Appendix B

Department	Reviewer	Cycle	Comment #	Comment	Drawing/Document	Response
City of Ottawa - Planning	Kersten Nitsche	2	1	The Site Plan and Landscape Plan do not match. The Site Plan shows two vehicular lay-by areas on Miwaté Private to the south of Block 204. On the Site Plan, they appear to conflict with a planter curb and concrete sitting wall (north side of Miwaté) and pedestrian light post (south side of Miwaté).	N/A (General Comment)	Please refer to updated drawing set - the vehicular lay-by illustrated on the Site Plan has been removed.
City of Ottawa - Planning	Kersten Nitsche	2	2	Please provide a Site Plan and Landscape Plan that does not include the vehicle pathways and turning movements as the linework makes these plans difficult to read. Please shift the vehicle movements to a stand-alone plan that minimizes other linework (e.g., landscaping hatching, etc.) so that those movements are clear and easy to read.	A100 - Site Plan L1.1, L1.2 - Landscape Plan Ground Floor	See Architectural Site Plan A101 where turning radii and vehicle pathway linework have been removed. Linework has also been removed from Landscape plans L1.1 and L1.2.

From: [Mottalib, Abdul](#)
To: [A

NOTES PLAN

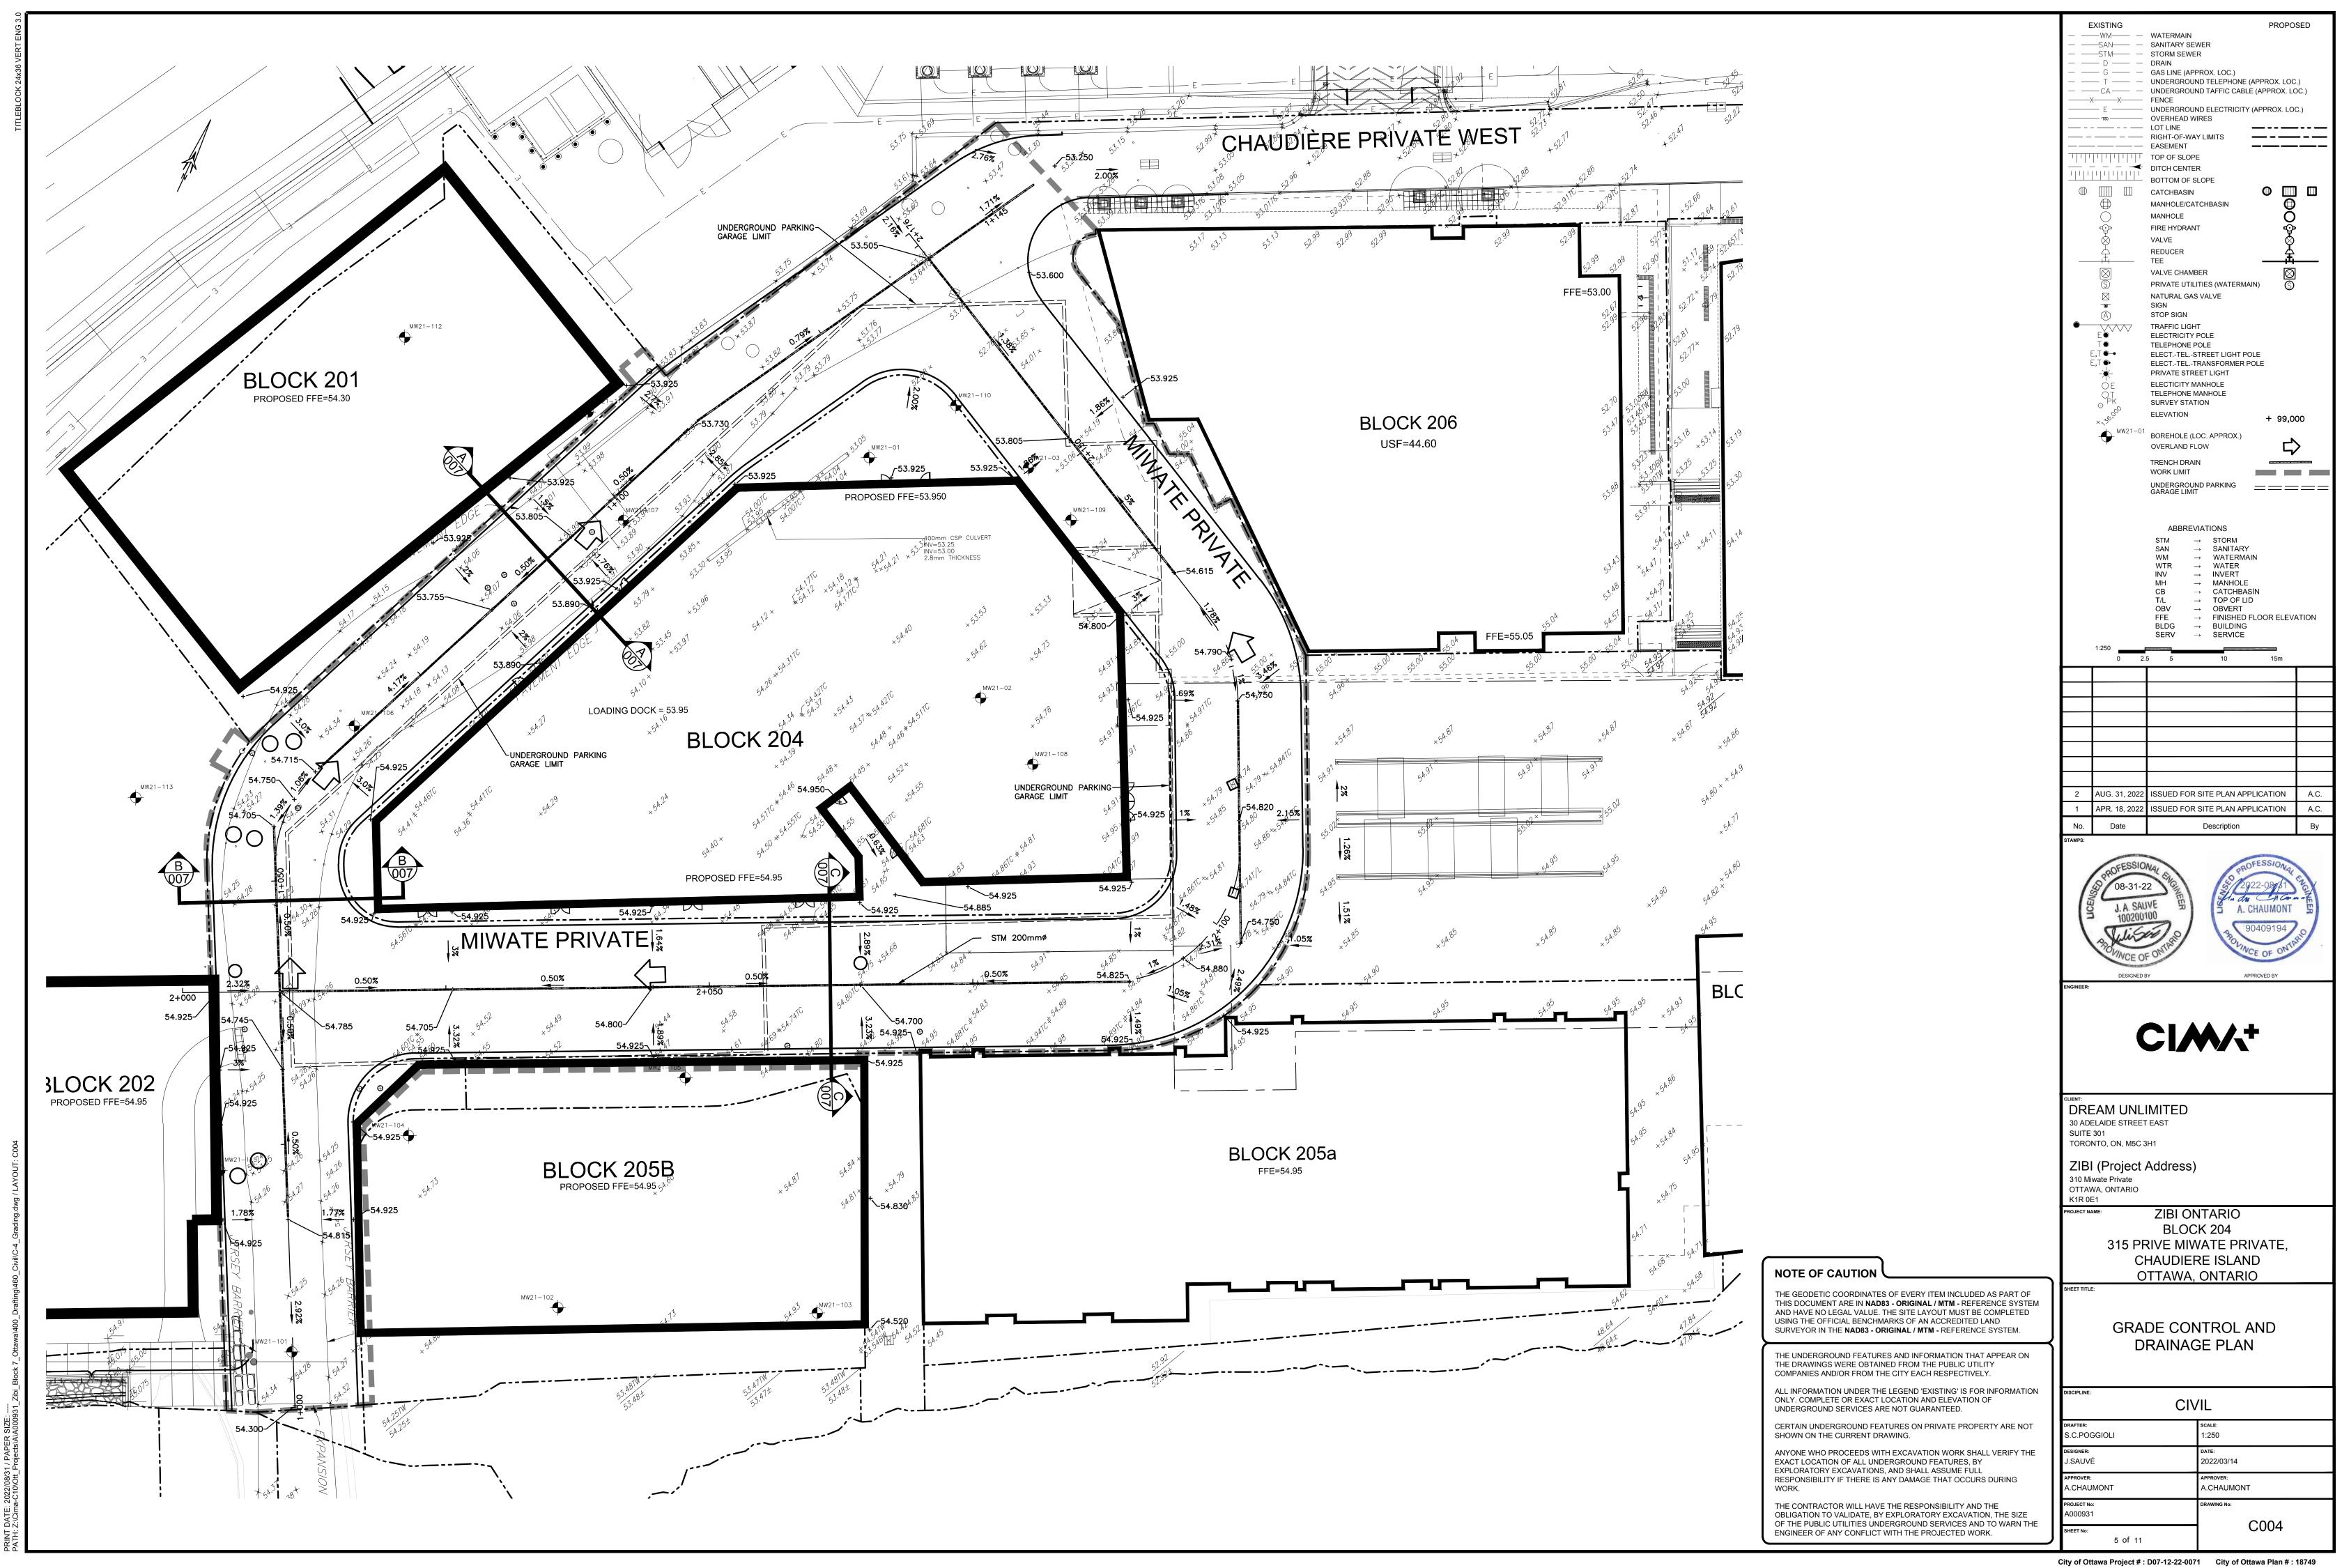
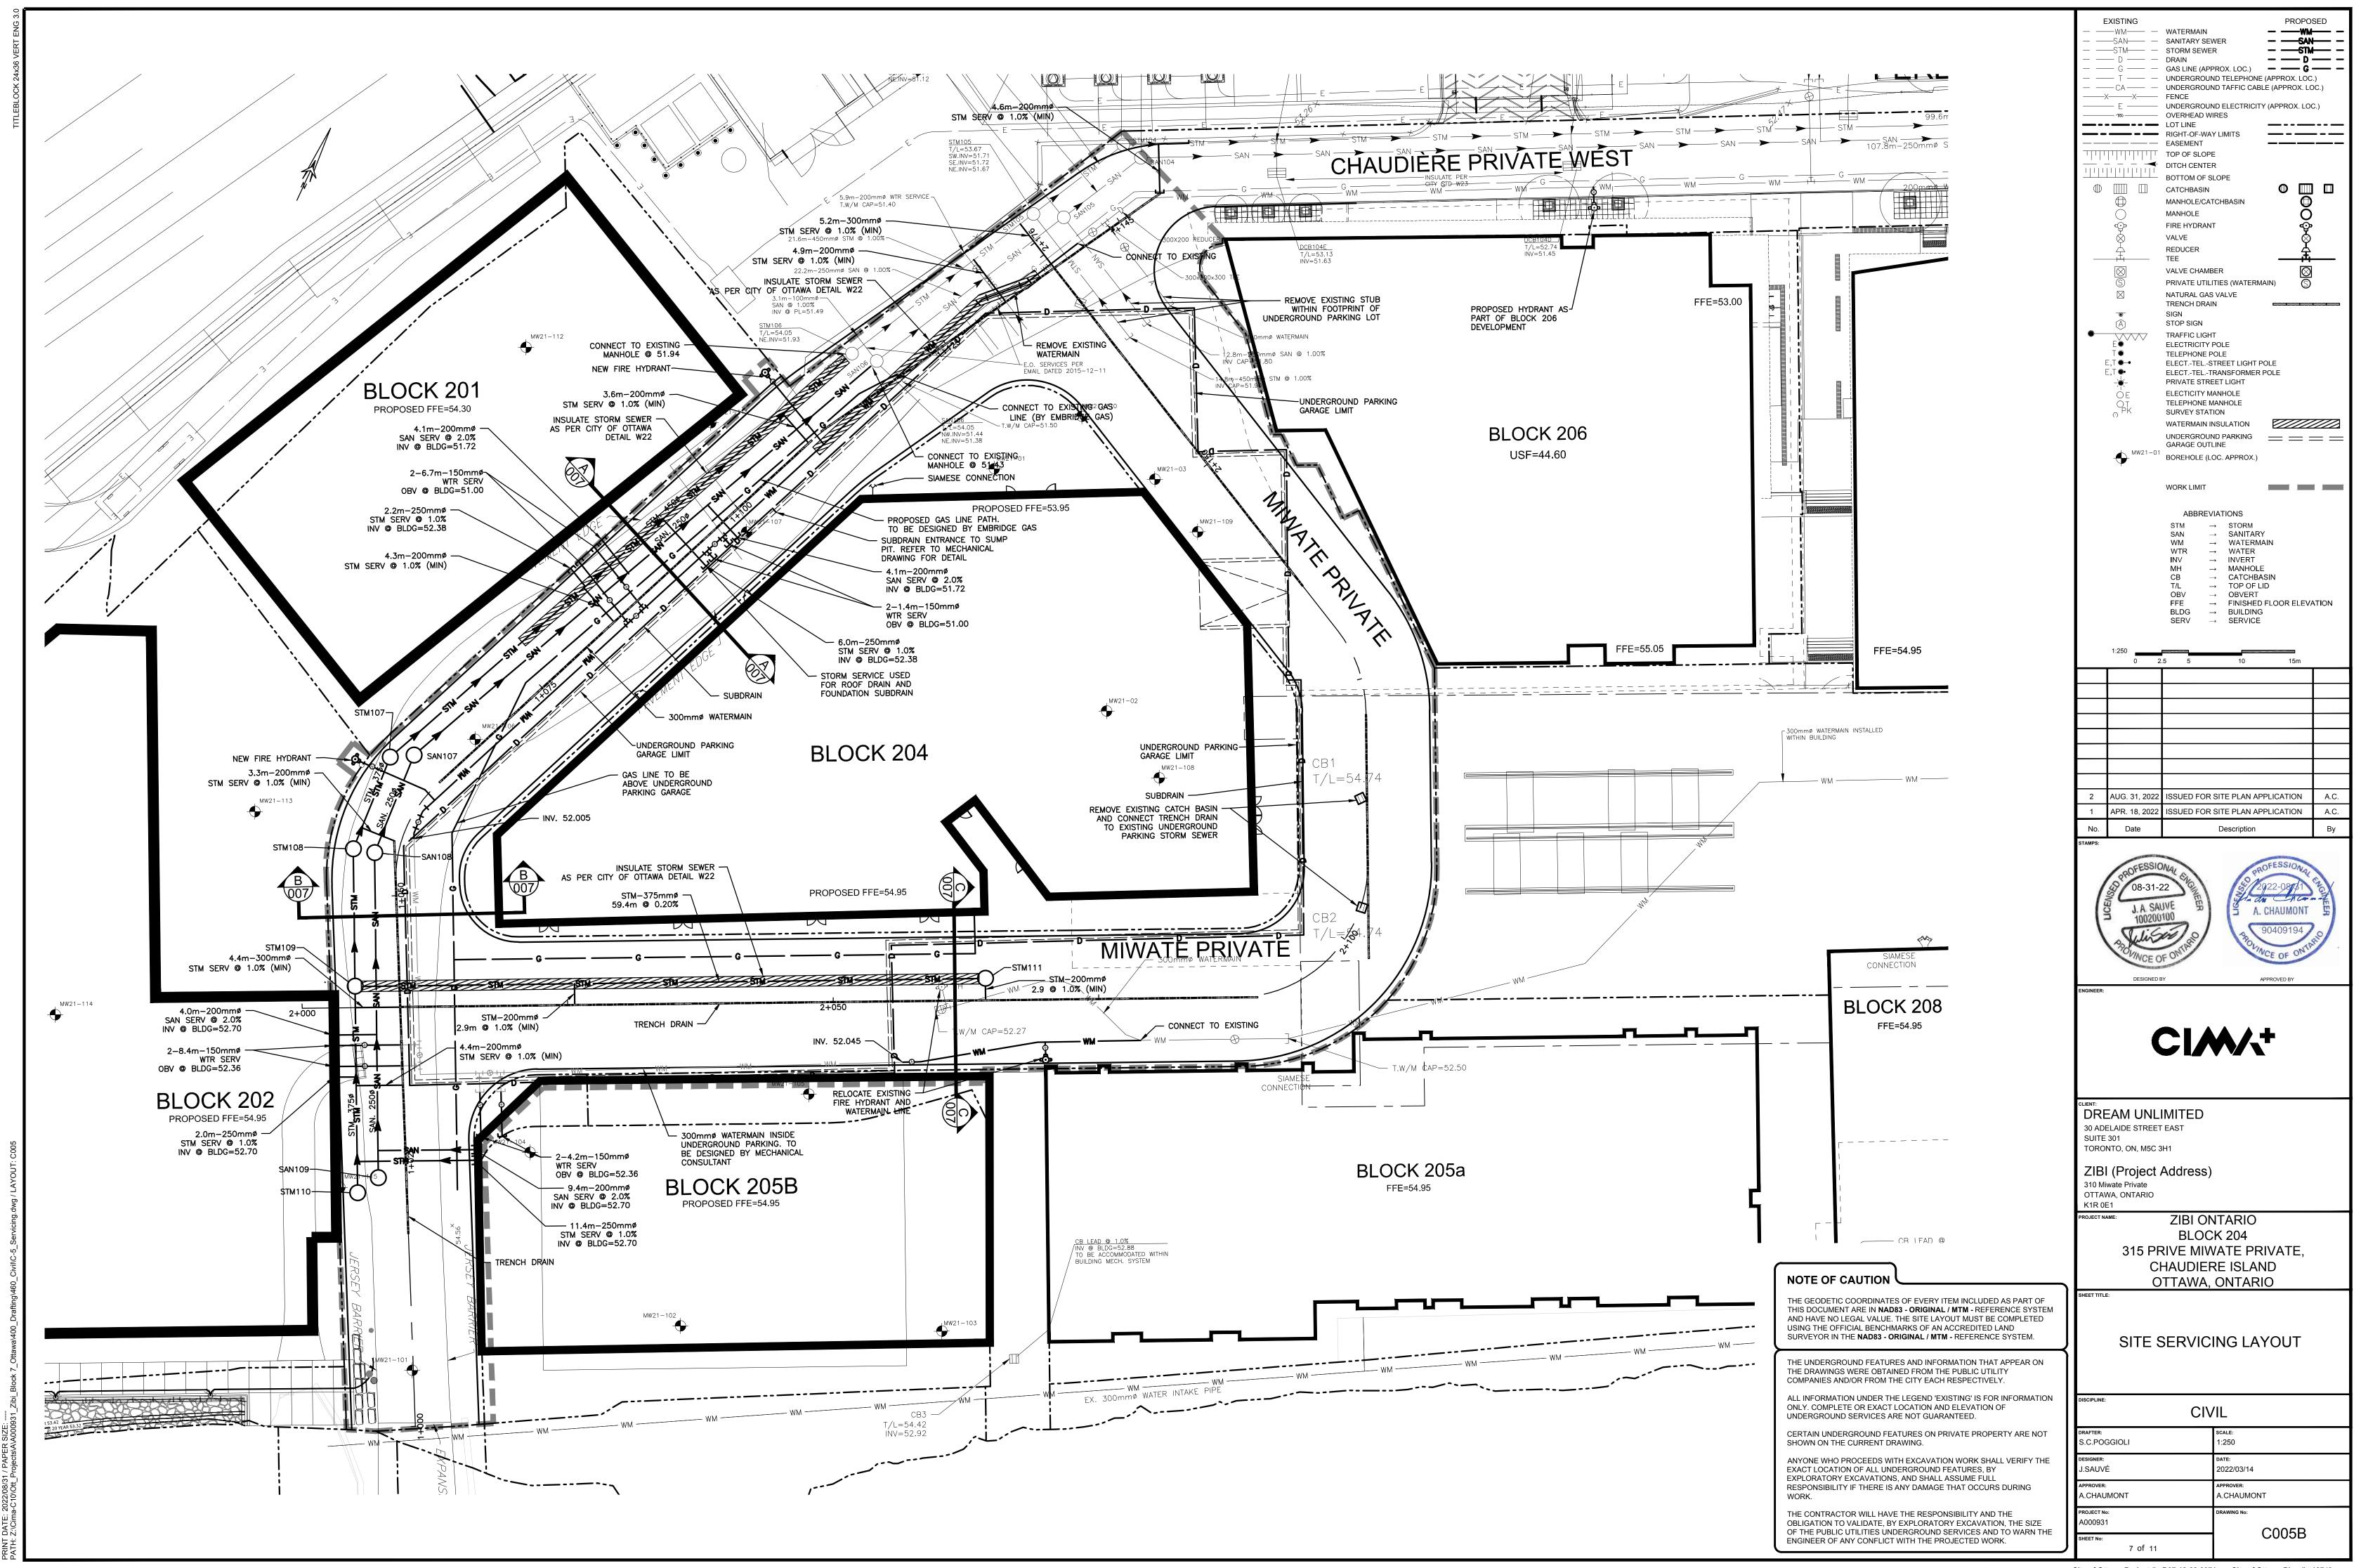
City of Ottawa - Infrastructure	Abdul Mottalib	2	15	Could you please include note 1 from the attached EC plan in your plan C003?	Site Servicing Layout: ZIBI Ontario-Block 204, Dwg no. C005B, Revision 2 dated August 31, 2022, prepared by CIMA+	Note added as requested to plan C003. See Note 1.1.
City of Ottawa - Infrastructure	Abdul Mottalib	(1) 2	(29) 7	(Cycle 1 - Previous) As the ZIBI site will have perimeter meters at the entrance, please put specific notes regarding this on the plan as before. (Cycle 2) please note the requested above note is very important and required for the servicing plan specifically for issuing the CWNL, please add this note on the servicing plan in addition to the notes that was added in the "Notes Plan."	Site Servicing Layout, (interim): ZIBI Ontario-Block 204, Dwg no. C005A, Revision 1 dated April 18, 2022, prepared by CIMA+	The note 2.20 in the Services section - Drawing C002 -Notes Plan was copied on C0005B - Site Servicing Layout drawing to address this concern.
